FROM: Ian Gledhill **TO:** Arun District Council
FAO: Clare Potts

SUBJECT: P/140/16/OUT - Outline application for access only - mixed use development comprising of up to 400 dwellings, a care home with up to 70 beds, a Local Centre comprising up to 2000sqm of A1/A2/A3/D1/sui generis floorspace, provision of land for a 1FE primary school (with sufficient space to ensure that it is expandable to 2FE), provision of land for a scout hut, safeguarding of land to help link the site to the Pagham Harbour Cycle Route & other community uses including public open space & allotments with some matters reserved. This application is a departure from the Development plan

Land South of Summer Lane & West of, Pagham Road, Pagham, West Sussex

DATE OF SITE VISIT: 24th January 2017

Unnamed Junction
PRC: -26.5 %
Total Traffic Delay: 65.2 pcuHr

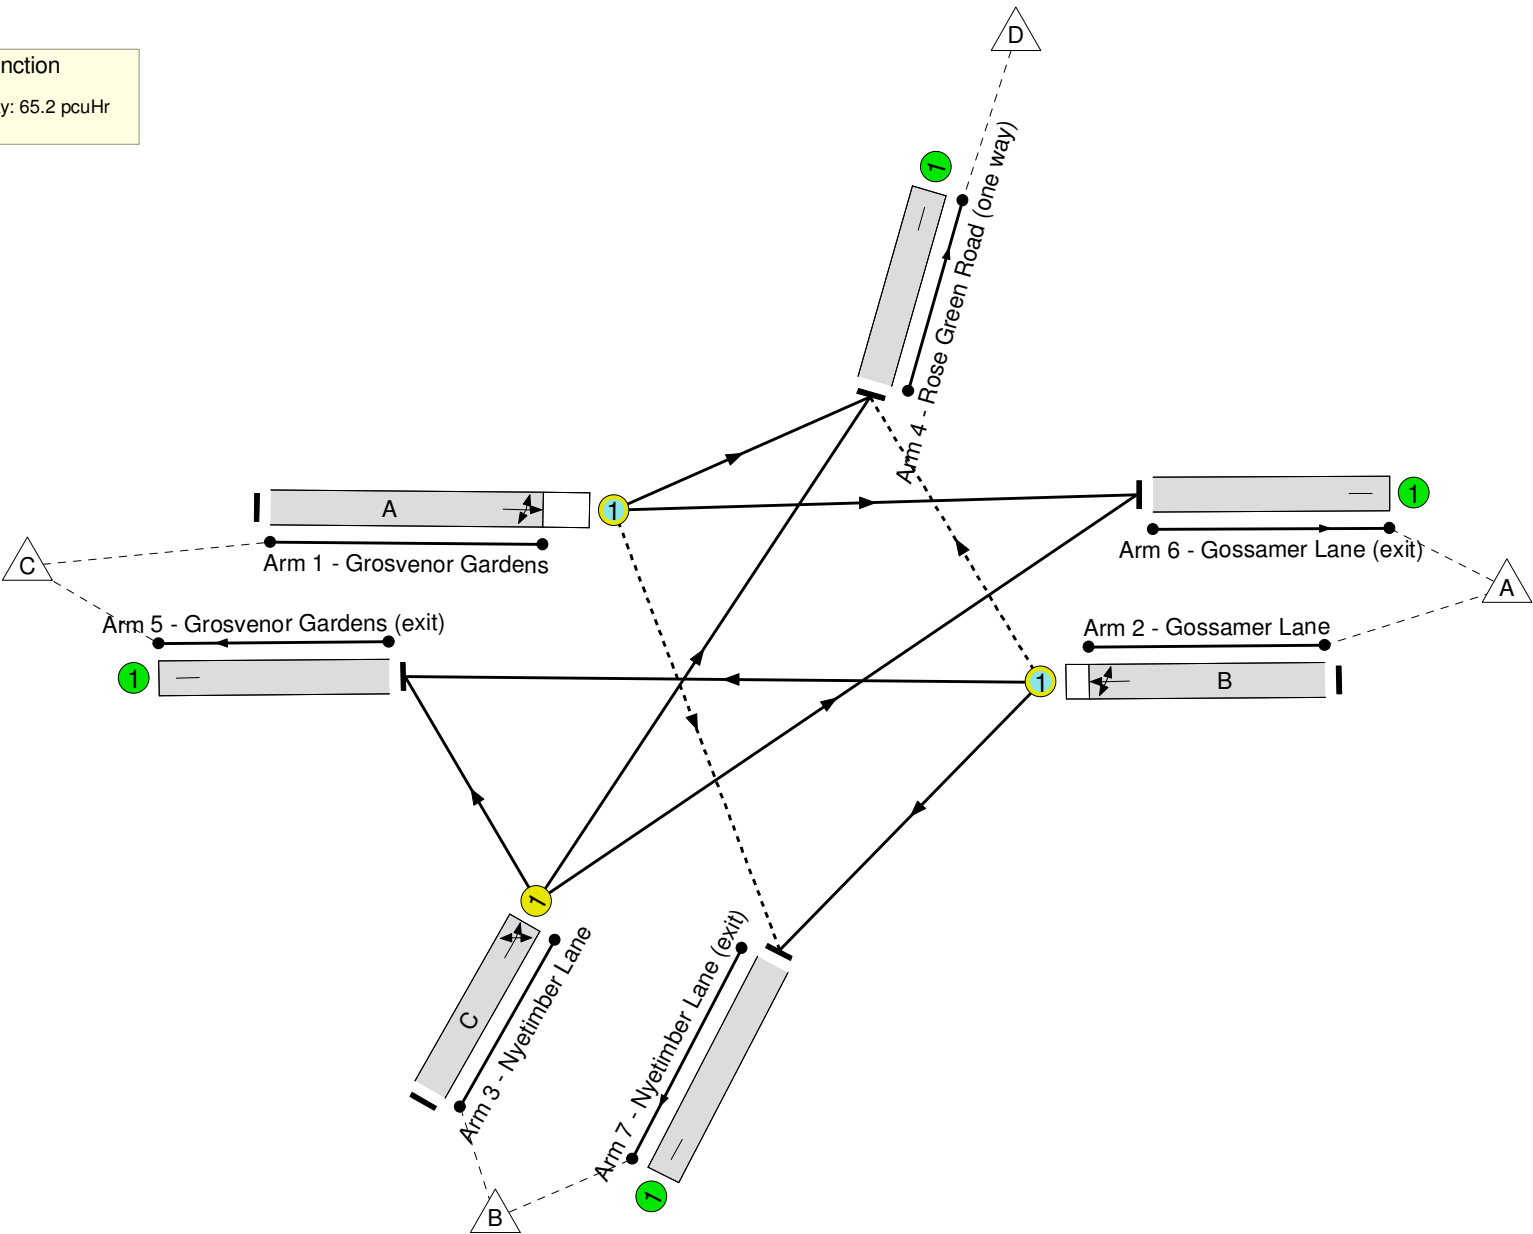
32. Capacity issues are also forecast at the signalised junction of Rose Green Road/Gossamer Lane/Nyetimber Lane/Grosvenor Gardens. However further clarification is required over the inputs used within the modelling; the outputs provided within appendix 22 of the TA are incompletely and do not include the LinSig stages diagrams or the link input data tables. From the information that has been provided, it would also appear that the pedestrian phases have not been included. The summary outputs are therefore viewed with a degree of caution.
